COUNTY COUNCIL'S RESPONSE TO CONSULTATION ON THE FOLLOWING DEVELOPMENT PROPOSAL

Application no: 25/01510/OUT

Proposal: Outline planning application for the erection of up to 500 dwellings and commercial floorspace (Use Class E) with associated access, open space and infrastructure - All Matters Reserved except for Access.

Location: Land South Of Perdiswell Farm, Shipton Road, Shipton On Cherwell

JOB TITLE		SOUTHEAST WOODSTOCK		CLIENT		BLENHIE PARTNERS	
DRAWING TITLE							
ACCESS STRATEGY OVERVIEW GENERAL ARRANGEMENT							
SCALE AT A0	DRAWN BY	DATE	DRAWING NO.	REVISION			
1:1000@A1	RM	03/12/25	23570-05-GA	E

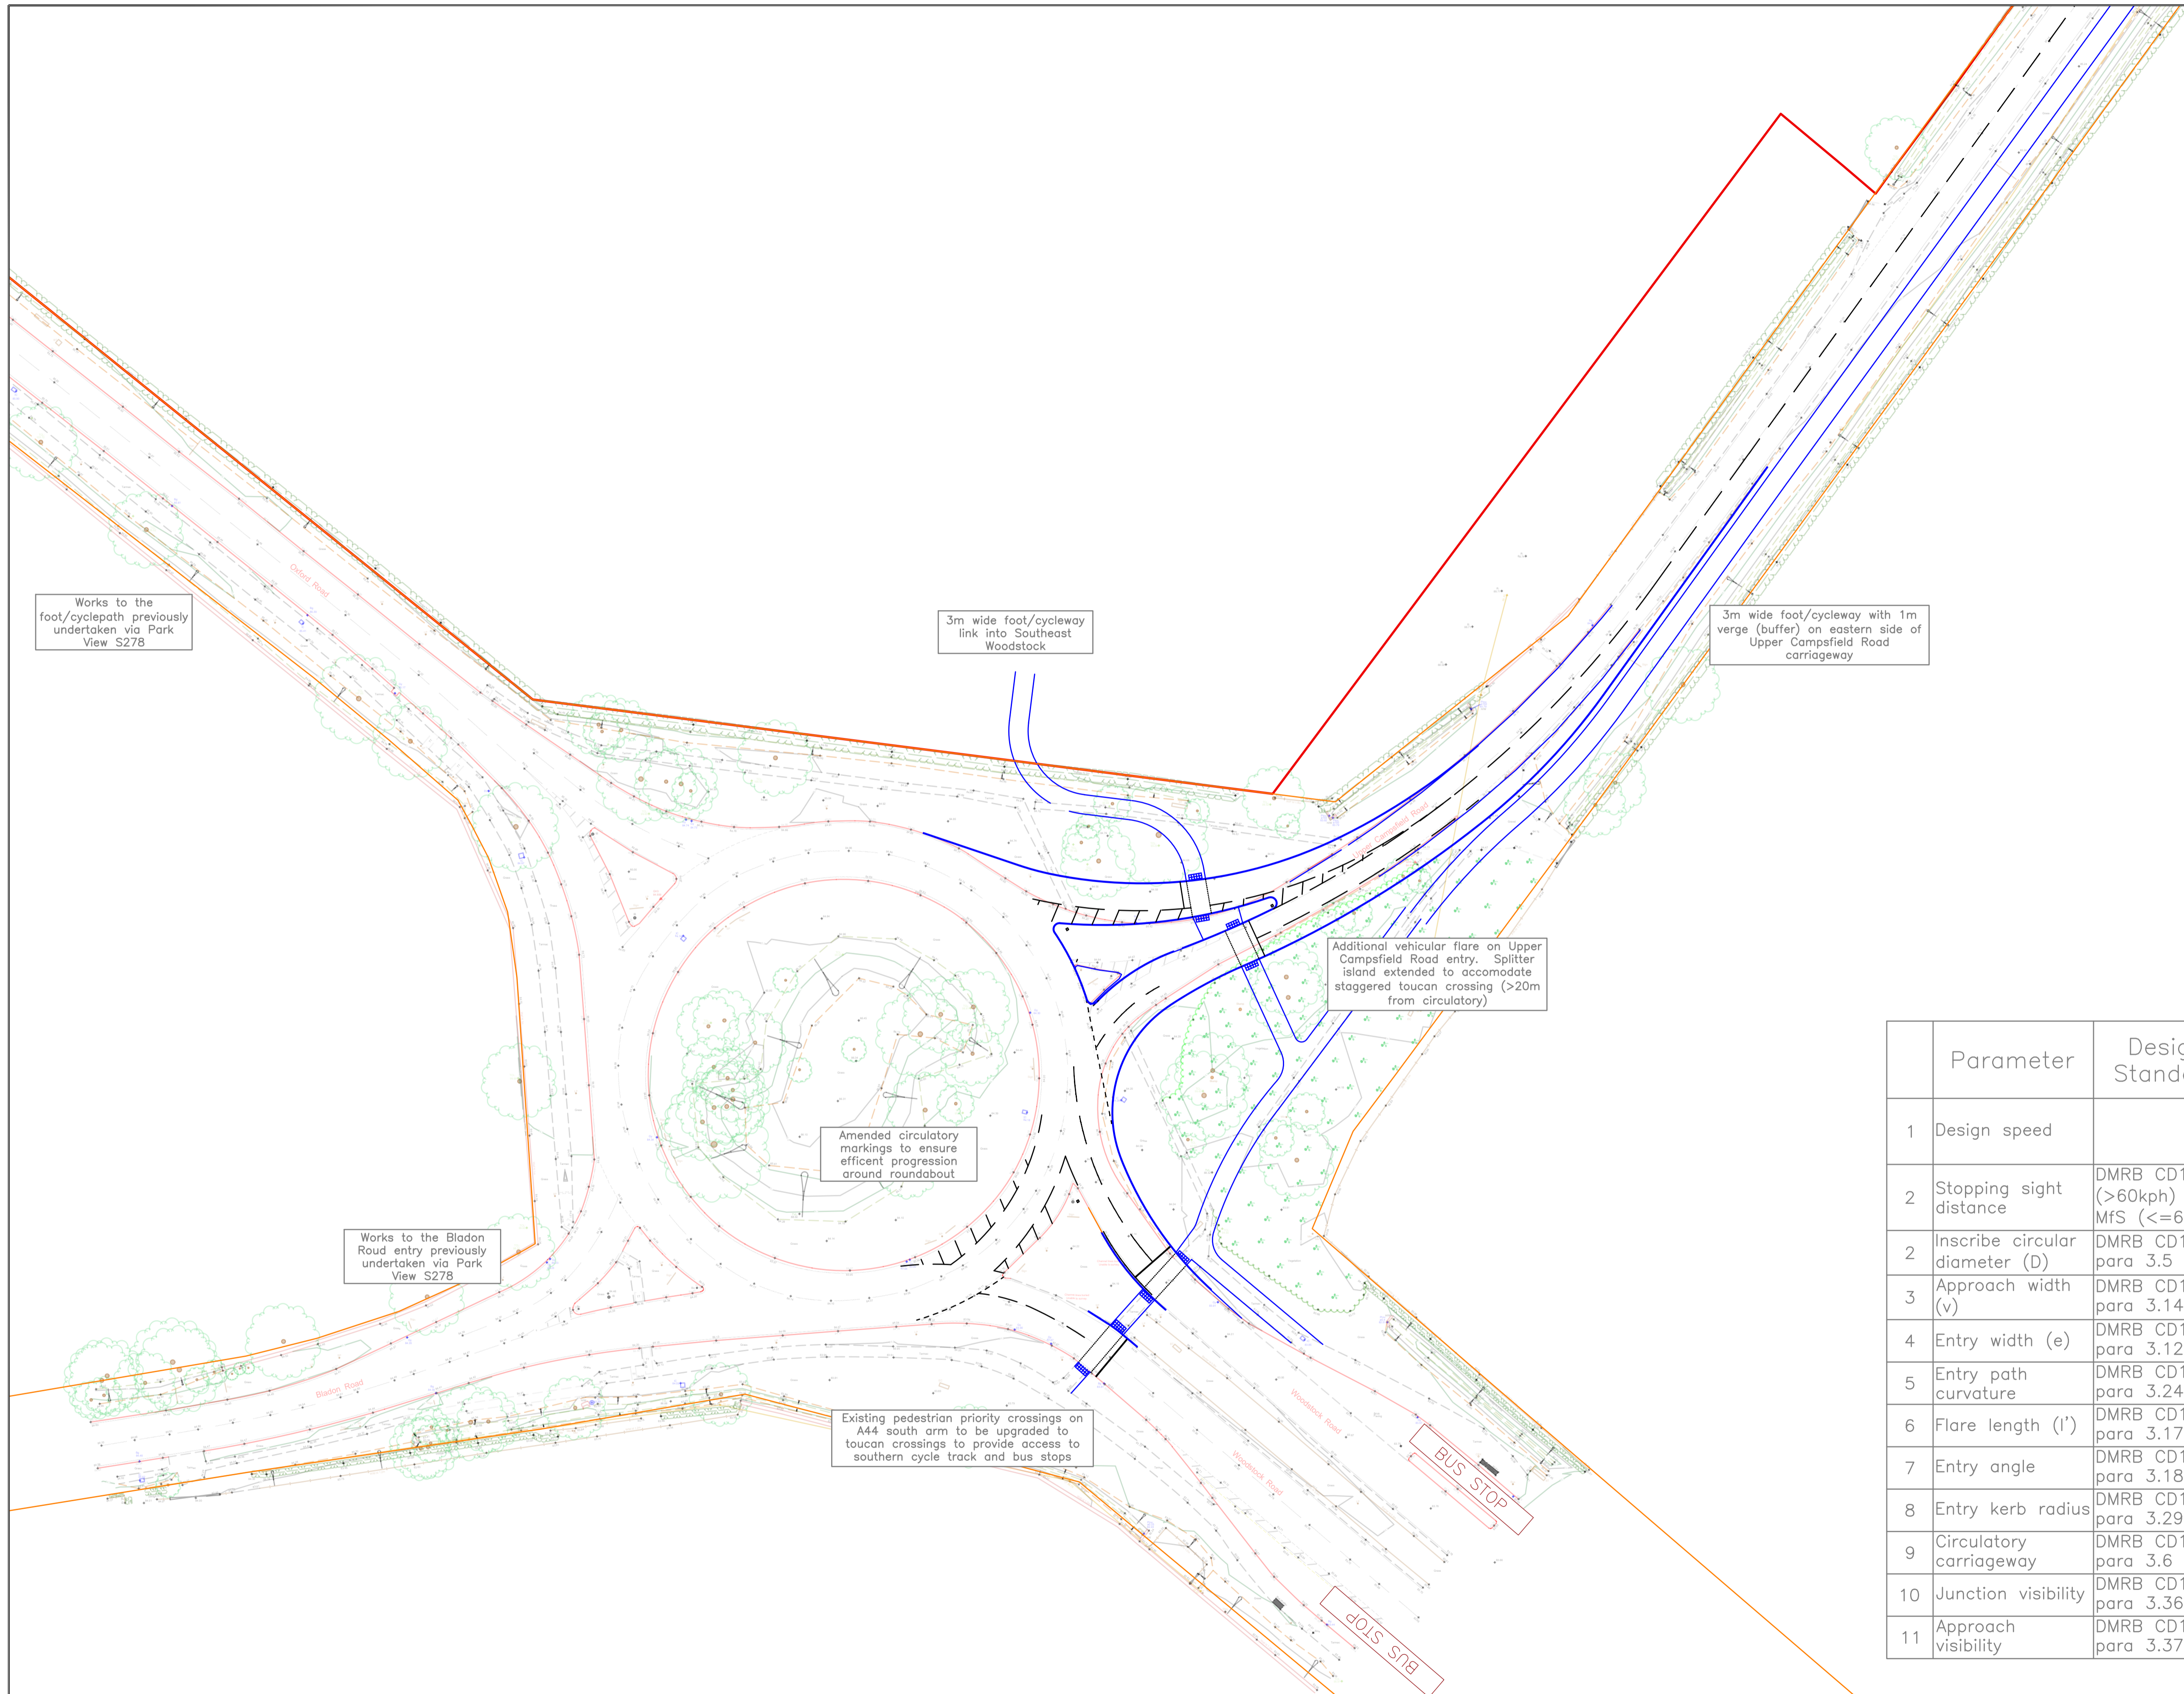
footway. The Access and Movement Parameter Plan and the Access Strategy Overview plans indicate additional pedestrian and cycle links that shall be created to adjacent infrastructure.

The application has also missed enhancing connectivity to the existing Public Footpath 265/36/10 across the A4095 Upper Campsfield Road, circa 170m north of the new roundabout. This is unacceptable and must ensure that the site seamlessly connects to existing infrastructure.

In addition, the site must provide a link to the northwest of the development, at the Cowells Road junction with Shipton Road appreciating that this is most direct route for school trips from this site. This would link onto the infrastructure identified as Route 26 in the Woodstock LCWIP as footway providing a link from the north of the Park View estate to Marlborough School.

JOB TITLE		SOUTHEAST WOODSTOCK		CLIENT		BLENHIEM PARTNERS	
DRAWING TITLE							
A44 BLADON ROUNDABOUT PROPOSED ACTIVE TRAVEL FOCUSED IMPROVEMENTS GENERAL ARRANGEMENT							
SCALE	DRAWN BY	DATE	DRAWING No	REVISION			
1:500@A1	RJM	03/12/25	23570-05-GA2	E

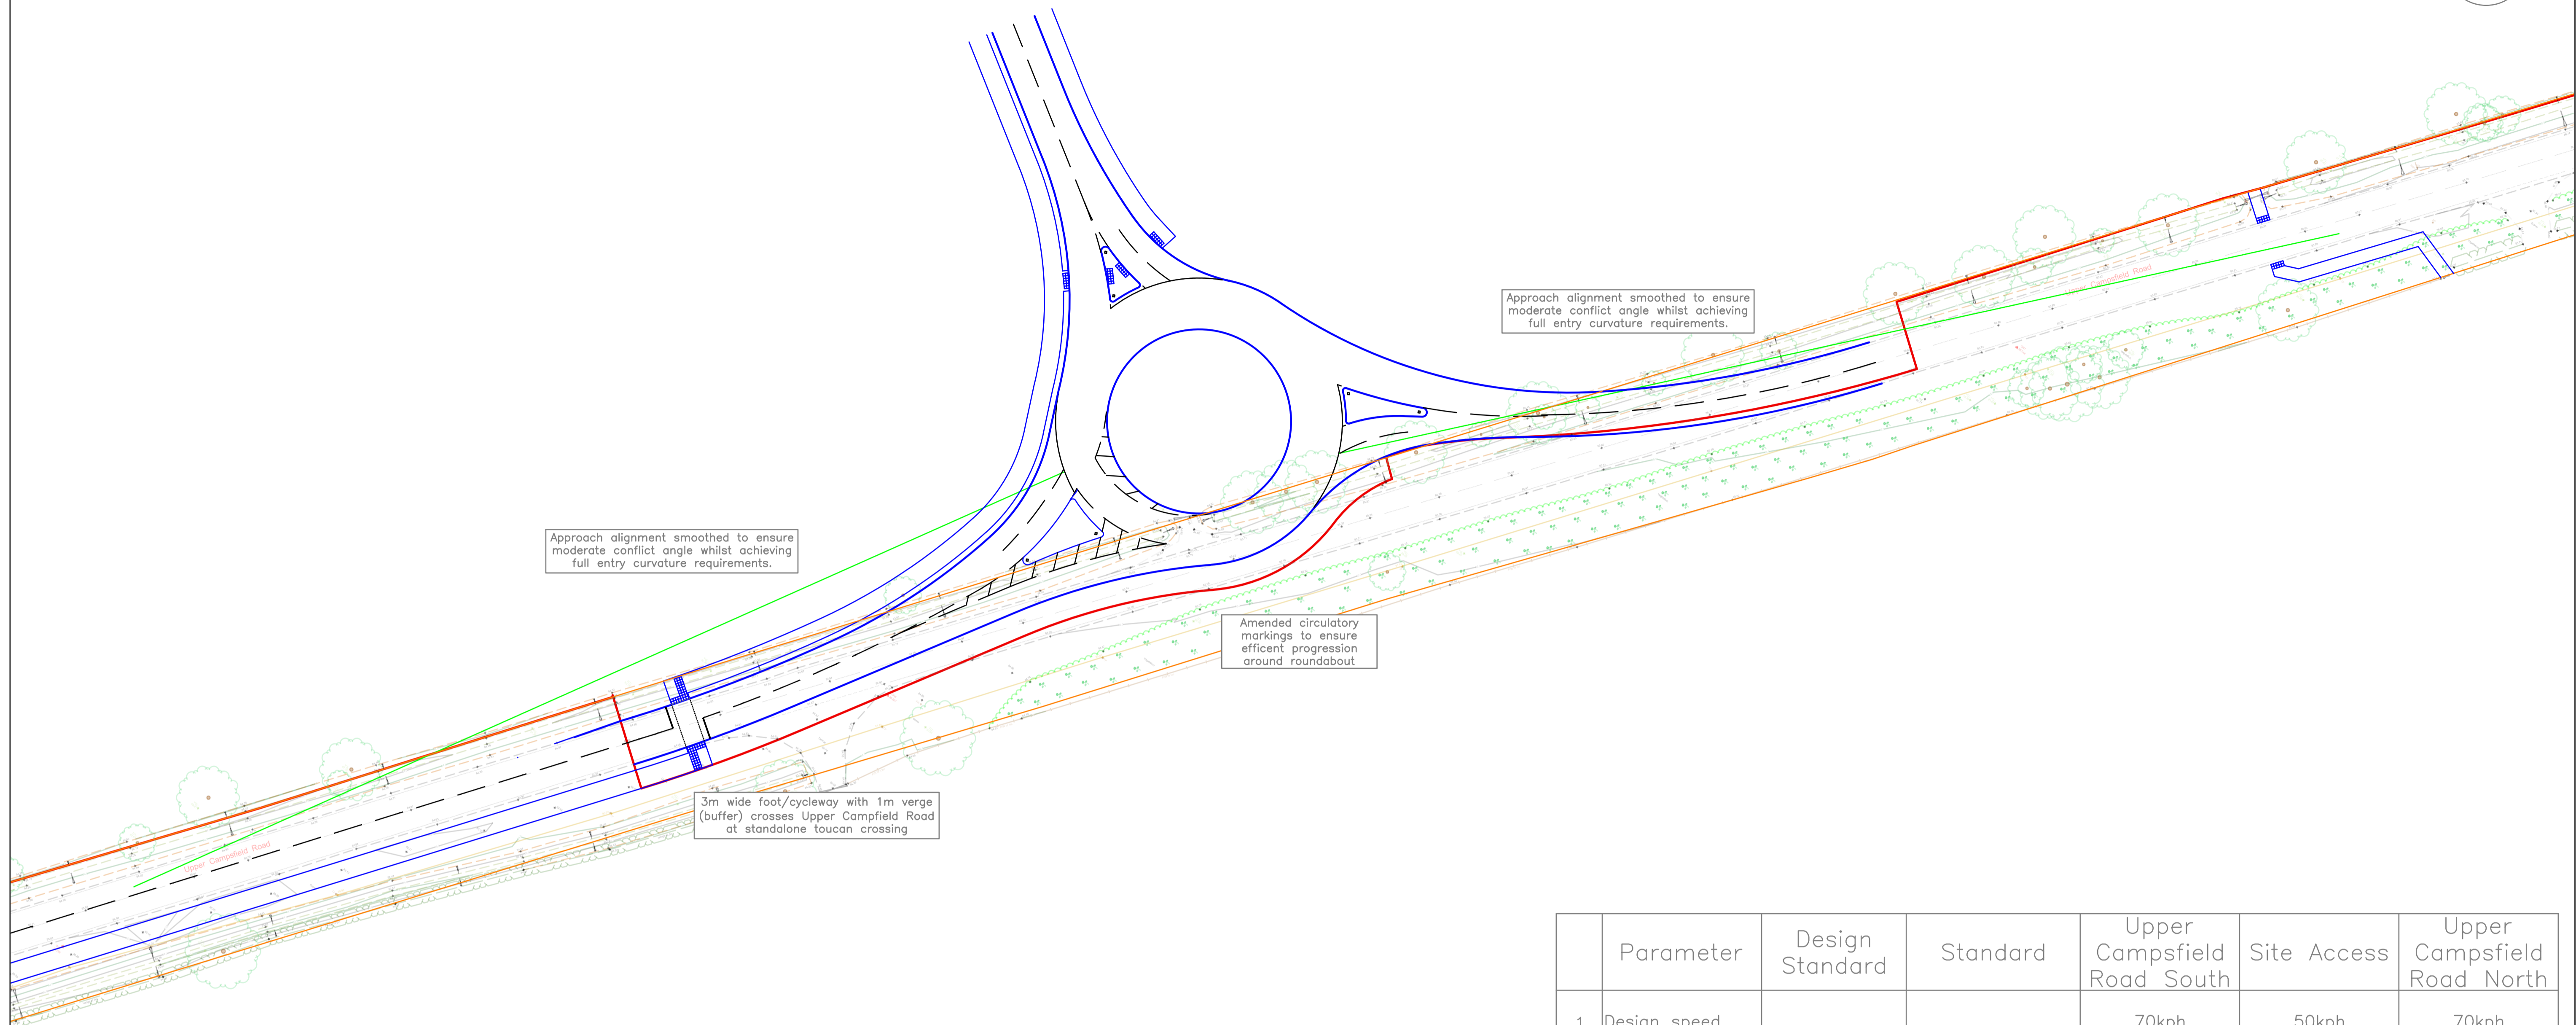
The proposed development intends to upgrade the existing uncontrolled crossing on the A44 Woodstock Road (southern arm of Bladon roundabout) to a toucan crossing to facilitate crossing for both pedestrians and cyclists as illustrated on *DTA Drwg 23570-05-GA2*. An additional toucan crossing on the A4095 Upper Campsfield Road arm and further northwest along the A44 Oxford Road, a new uncontrolled crossing is intended to be put in place.
